Town & Country Planning Act 1990 (as amended)
Town and Country Planning (Development Management Procedure) (England) Order 2015
Application for approval of matters reserved by condition imposed under BE/23/14/PL relating to
conditions 4, 11 & 12 - materials & finishes to be used for external walls, landscaping scheme &
new screen fences
Adjacent Warehouse site to McDonalds Southern Cross Trading Estate, 1 Oldlands Way, Bognor
Regis

Arun District Council have decided to **REFUSE** details reserved by condition for the following reasons:

The details submitted in respect of the landscaping condition namely the document referenced as Landscaping Plan by Lambert Smith Hampton (24 June 2015) is not considered to be acceptable and therefore does not satisfy the requirements of the condition. Please note the comments previously sent to you on 30 June 2015:

Drawing title:
Site Plan as Existing

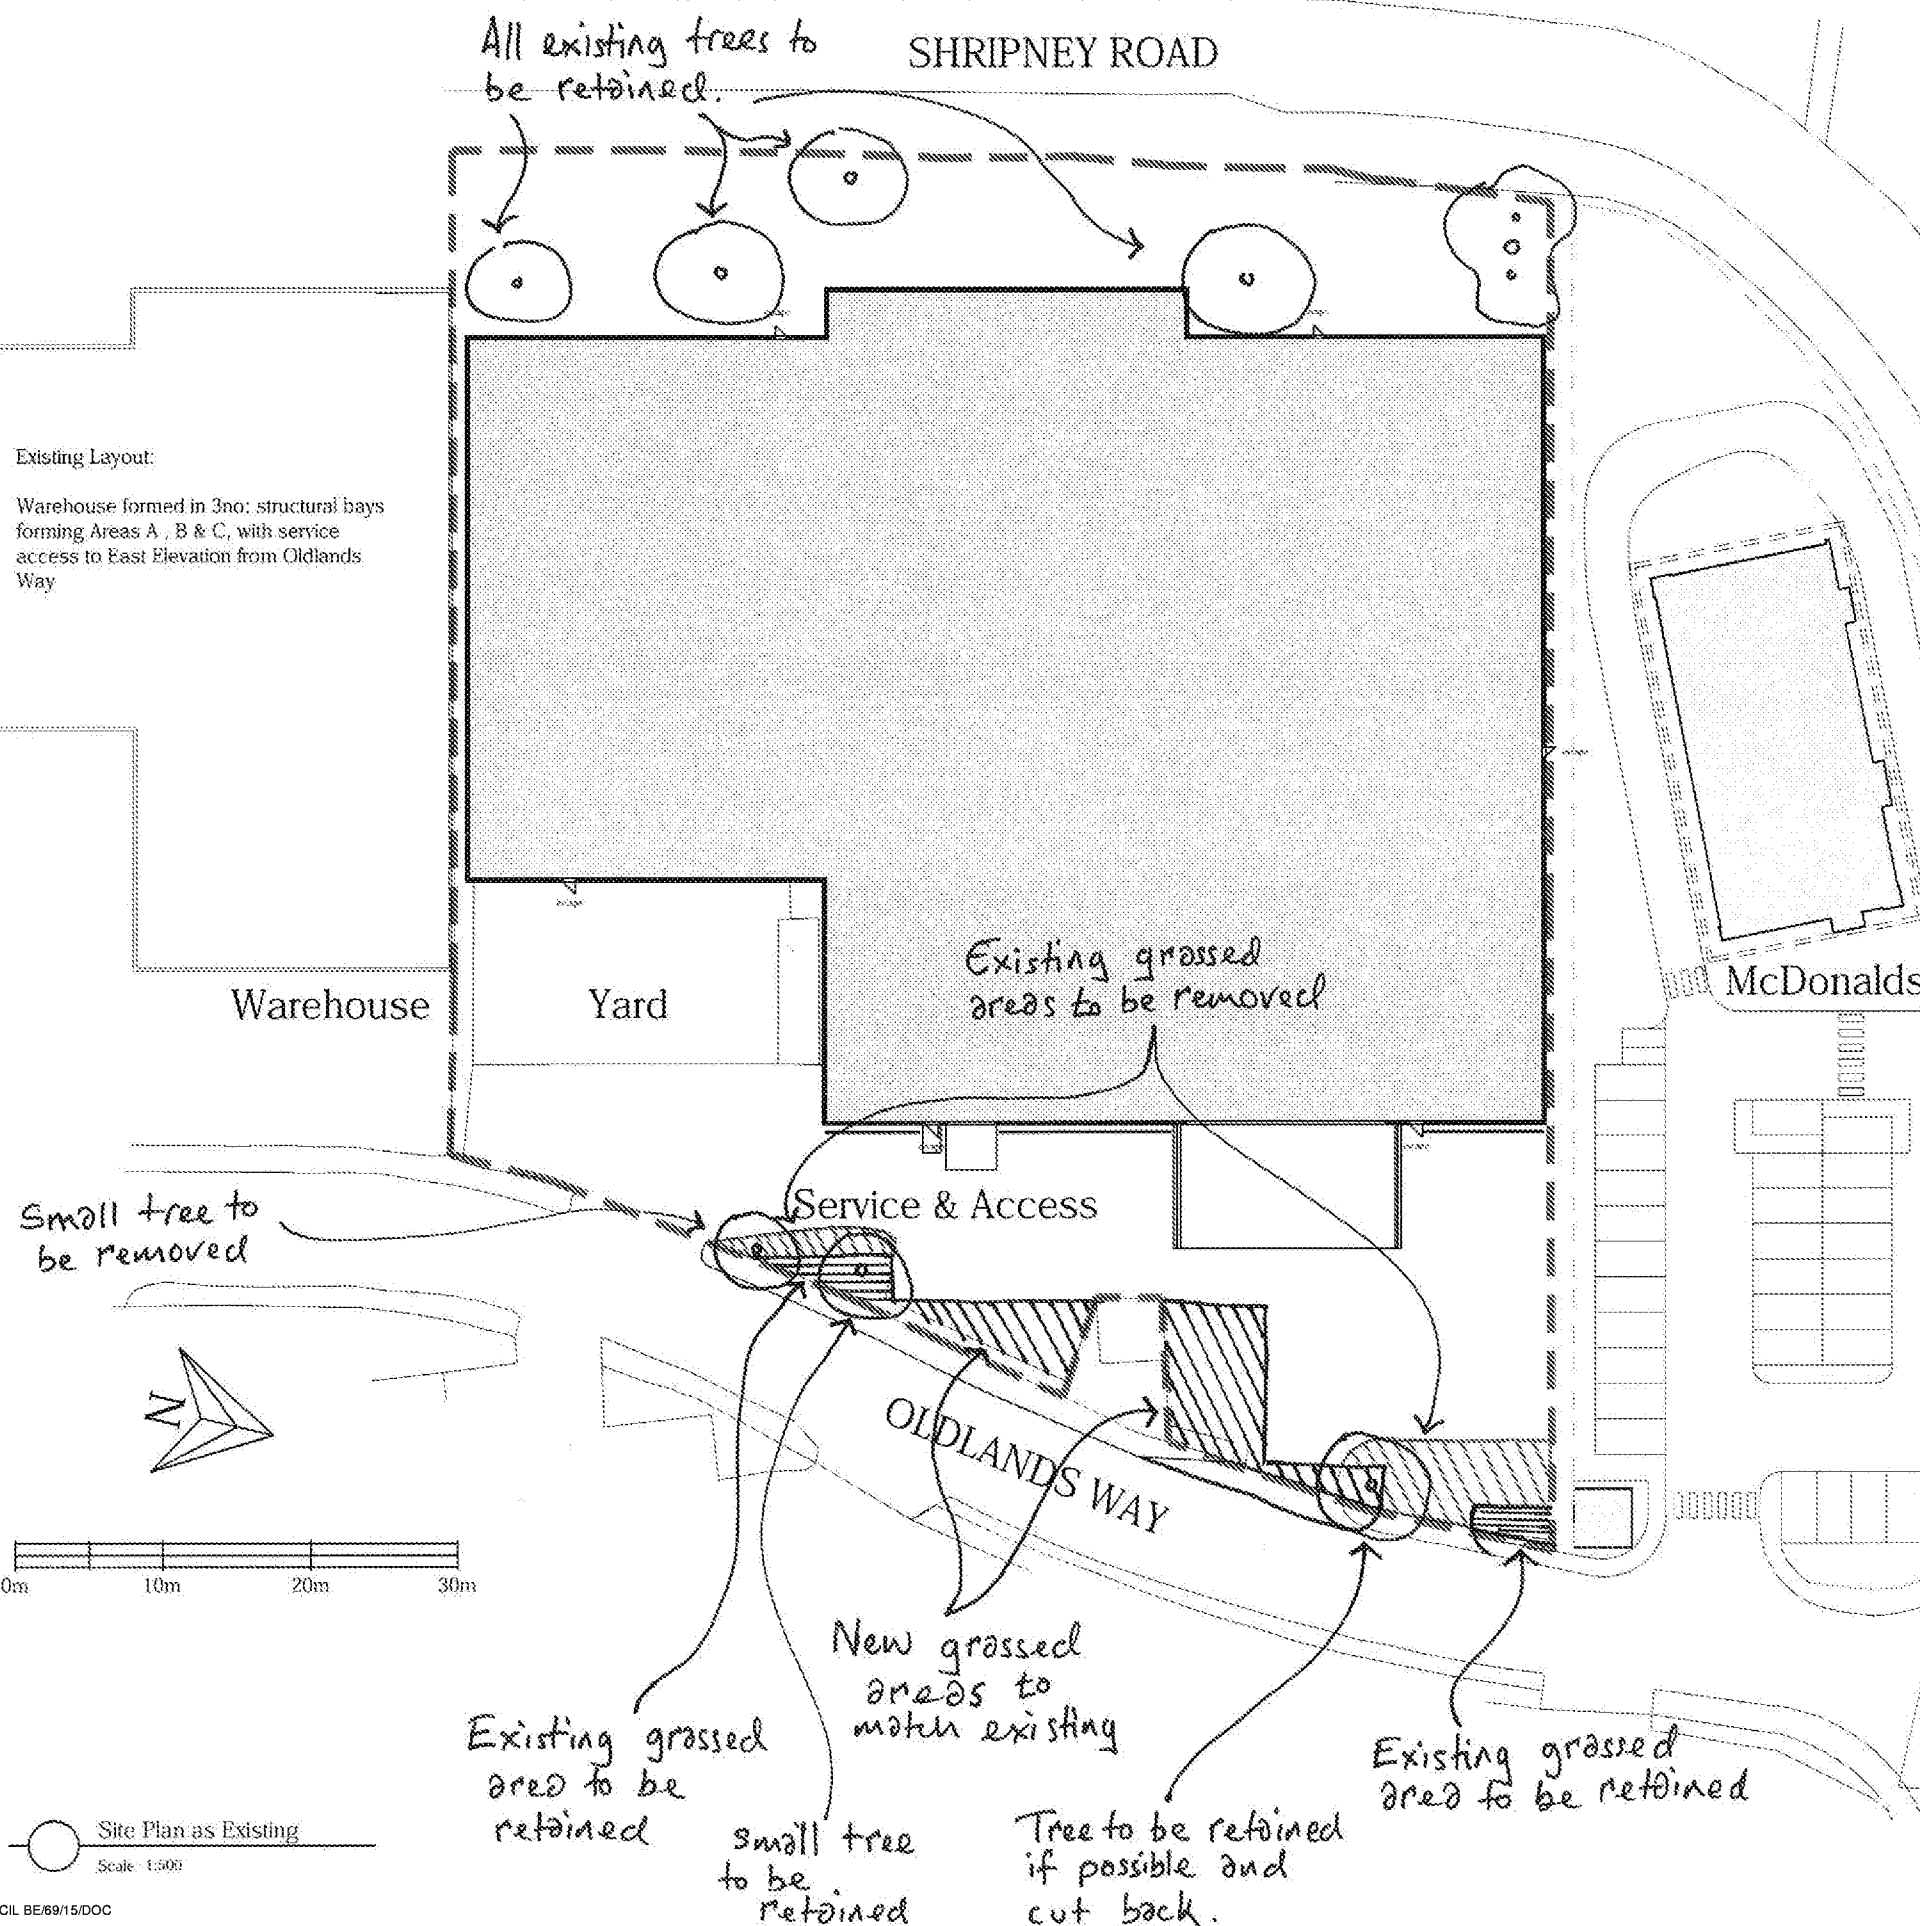
"* You comment on the tree to the front "to be retained if possible" - can we delete "if possible or add words "plant replacement tree if not possible to retain". If the latter, we would need to know the species & size.

* The new grassed areas to be landscaped at either side of the substation would benefit from docdeci

the addition of some planting rather than just grassed areas. We would recommend a compact form of tree species either Malus, Prunus or ornamental Acer.

Site Plan as Proposed

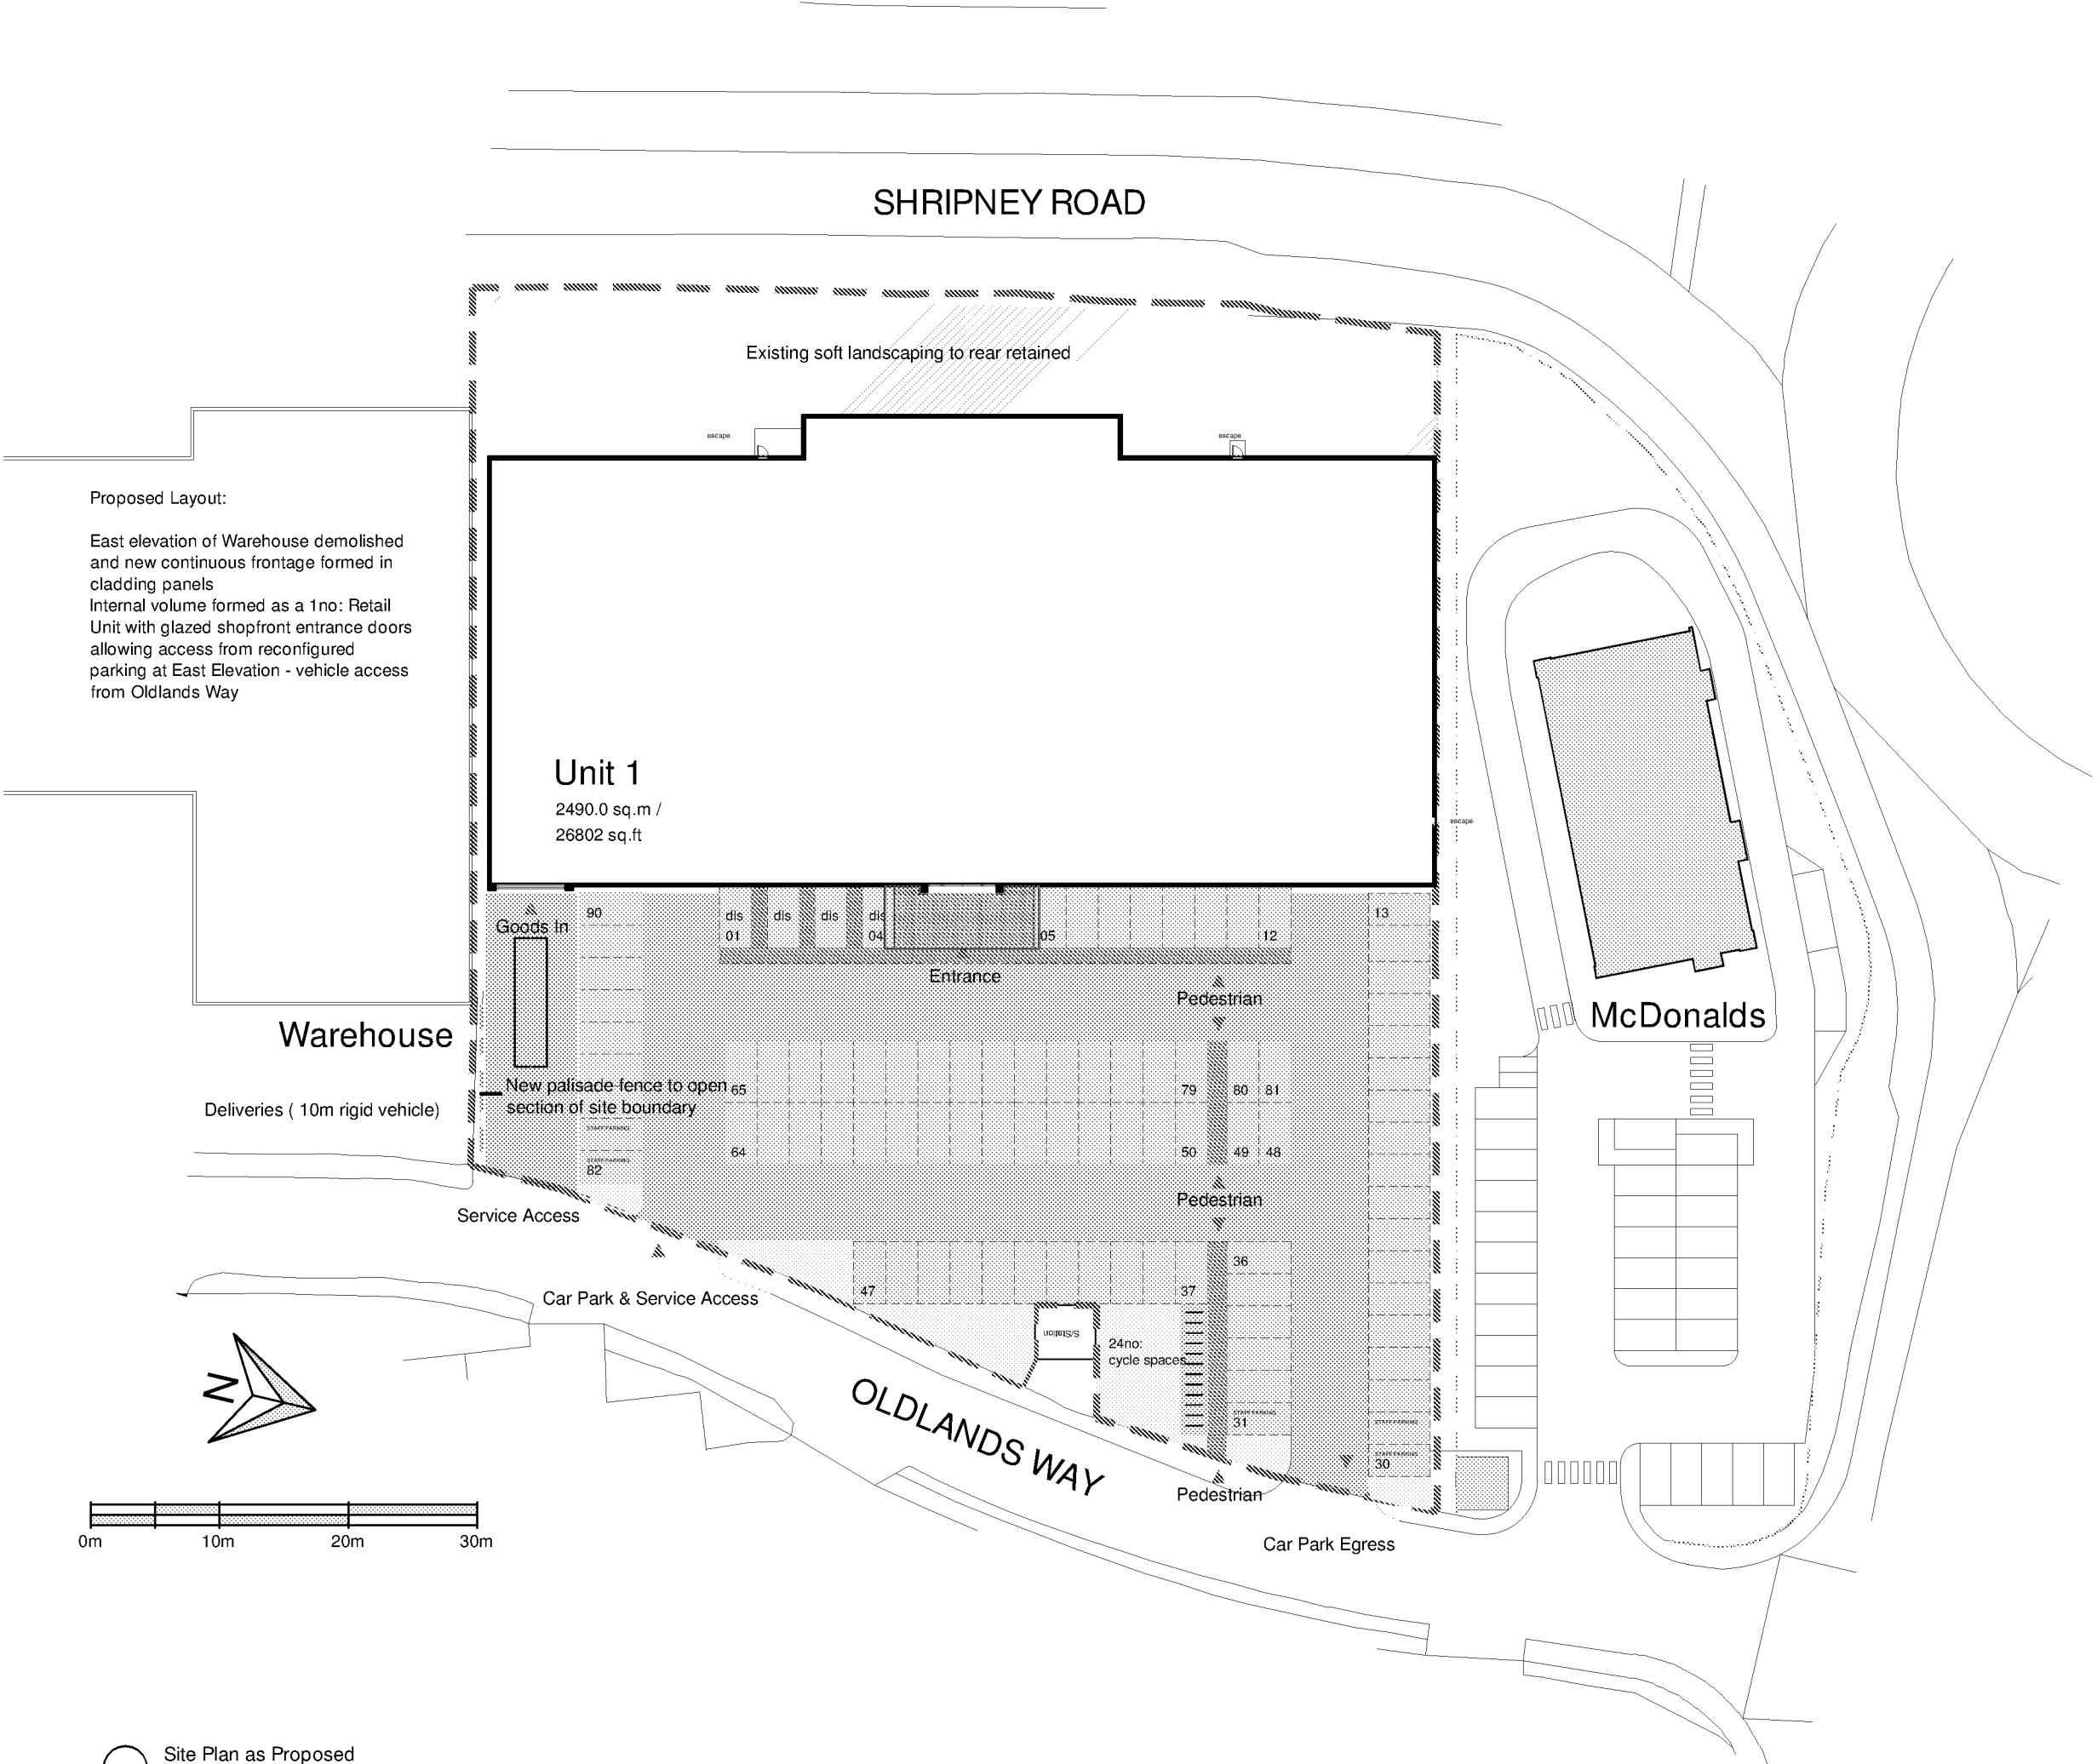
* The rear of the site could easily accommodate 2no new trees and these would need to be planted as a small standard size approx. 8-10cm girth, double staked and tied. As an alternative to trees, shrub species such as Photinia, Viburnum or Prunus could be considered in hedge form, planting at a minimum size of 3lt."
